My name is [REDACTED] **Morningthorpe and Fritton Parish Council.**

East Pye Solar - EN0110014

Morningthorpe and Fritton Parish Council – Follow-up from ISH1

Figure 4.2: Indicative Temporary Construction Compound Locations

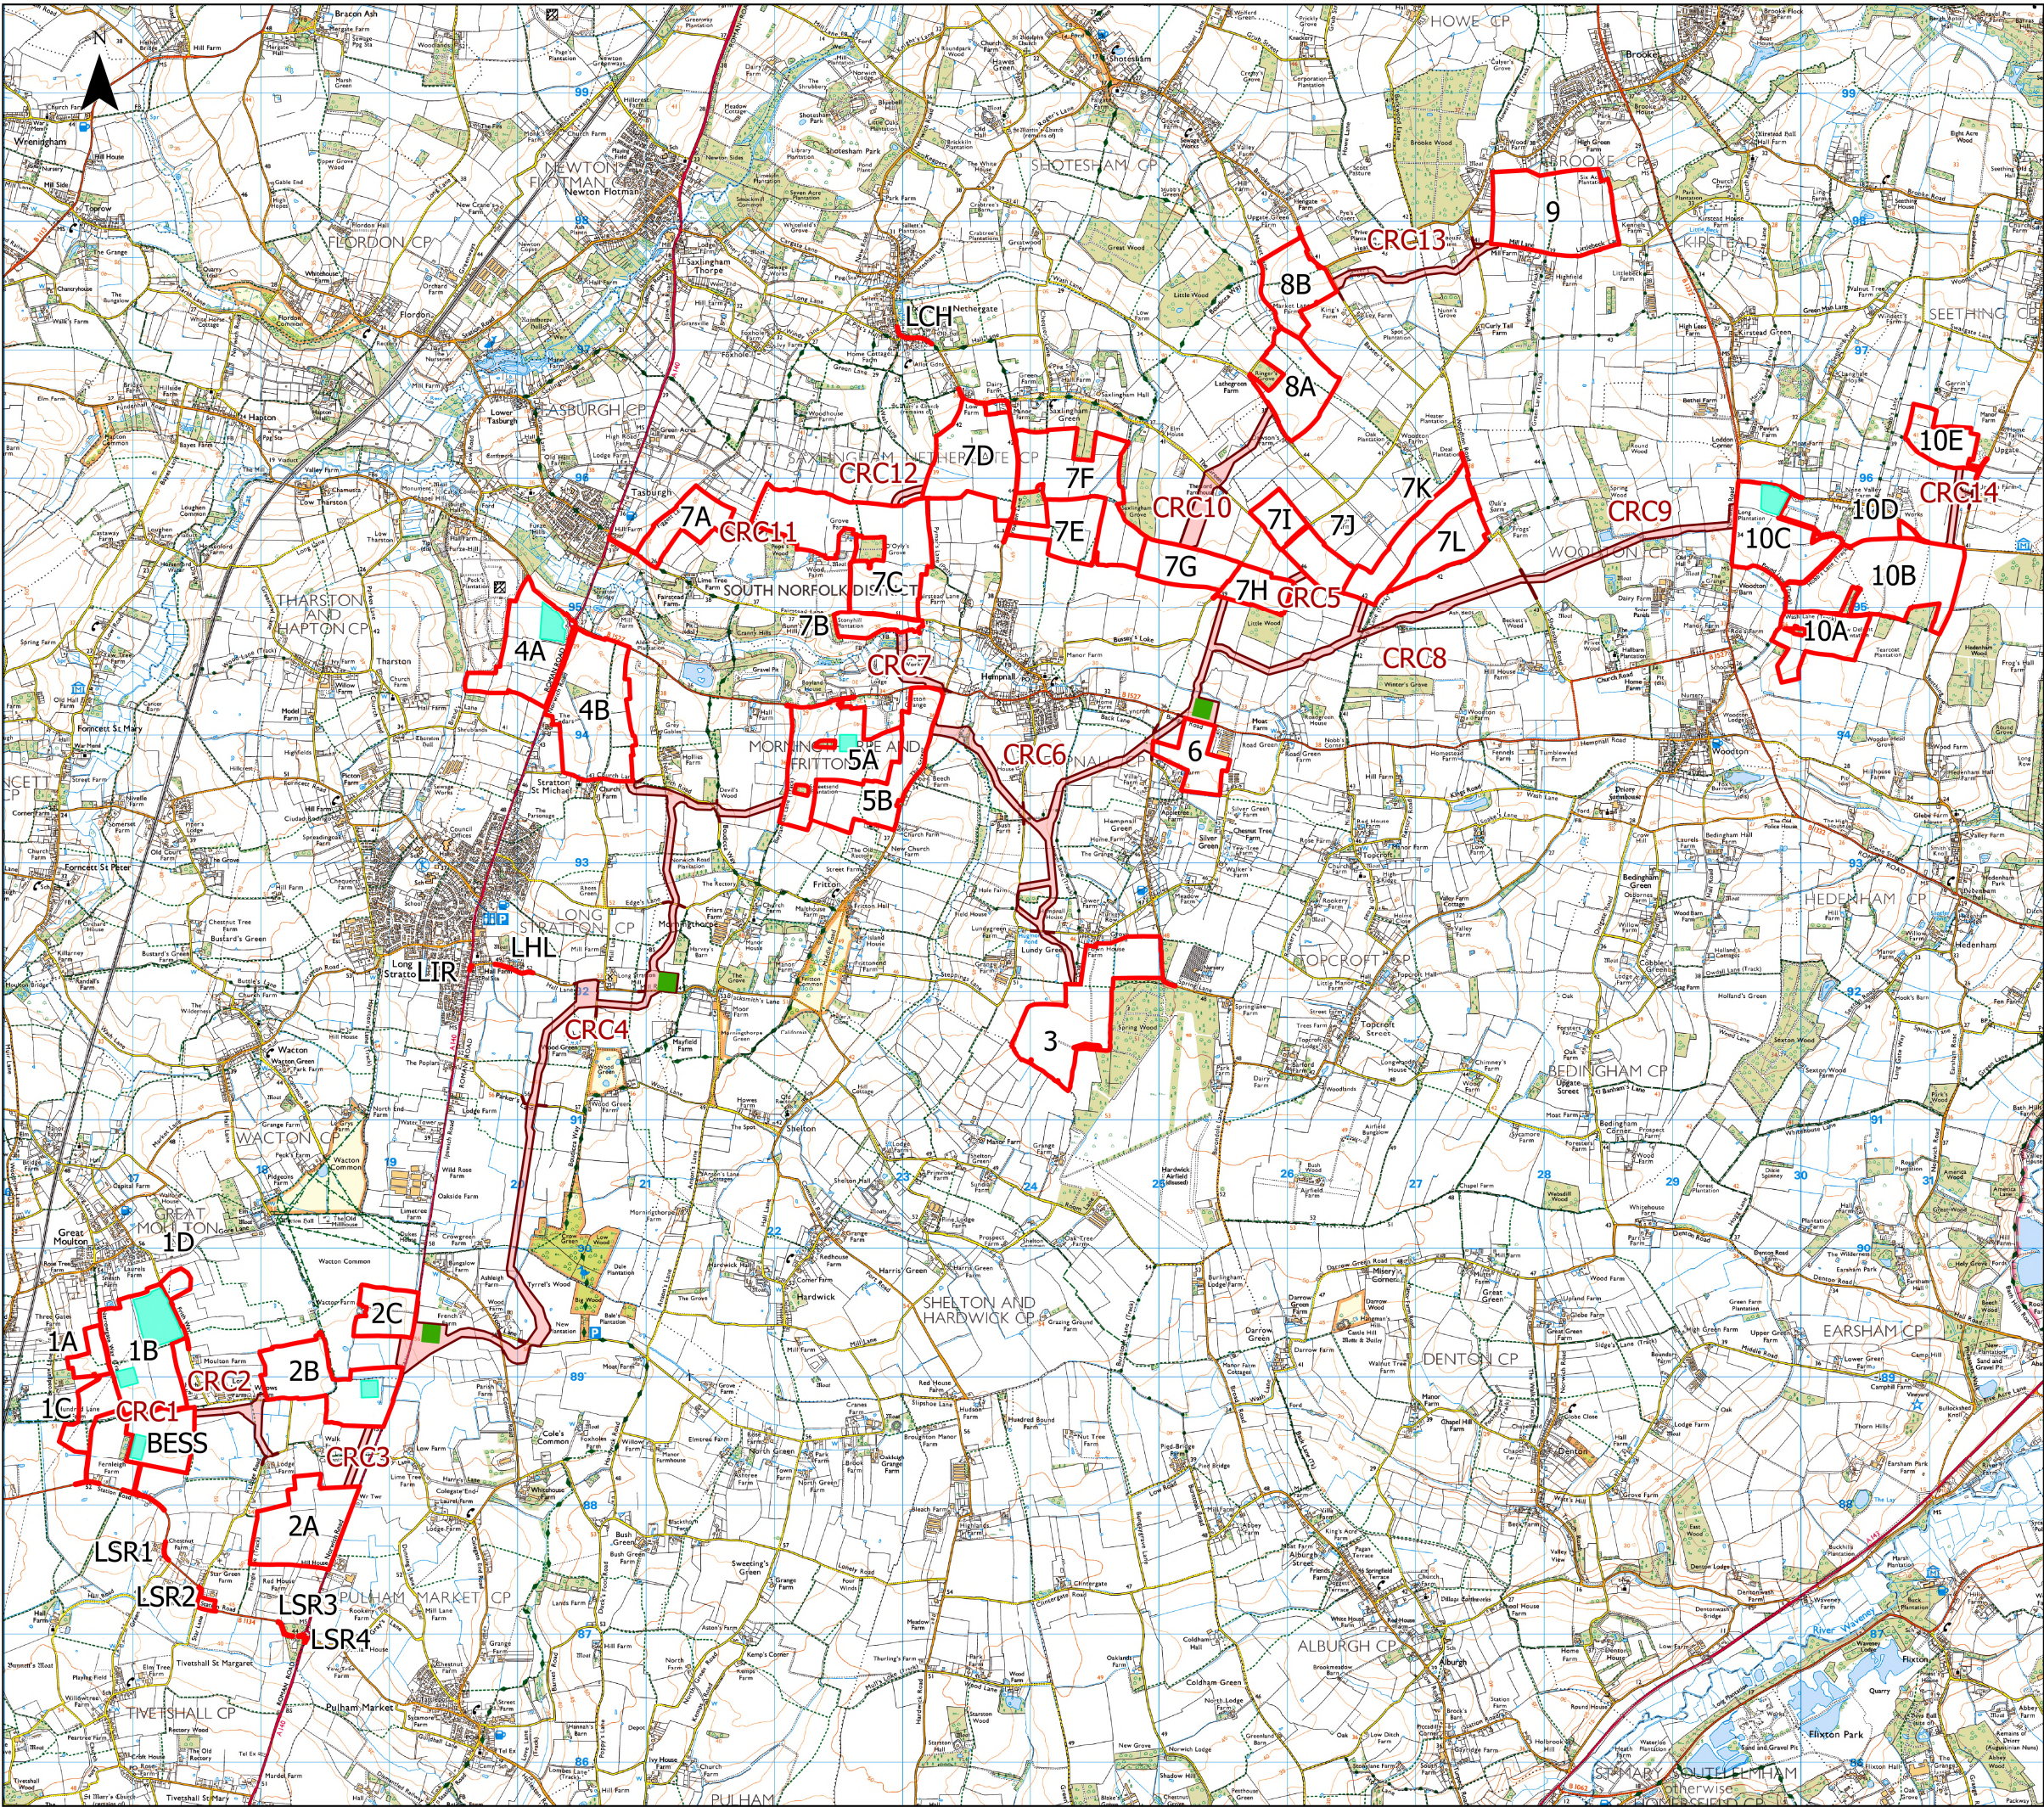
Morningthorpe and Fritton Parish Council (MFPC) raised a question at ISH1 regarding the proposed use of the construction compound at Site 5. MFPC sought clarification on whether the compound would serve Site 5 only, or whether it would also support other sites, such as Sites 7A–F, including for material deliveries, storage and personnel. MFPC wished to understand the potential impact of the compound on the local road network around Site 5, including routes from the A140 and Hempnall, as well as the potential impact on nearby residential properties and businesses. The Applicant's response did not provide a clear answer to this.
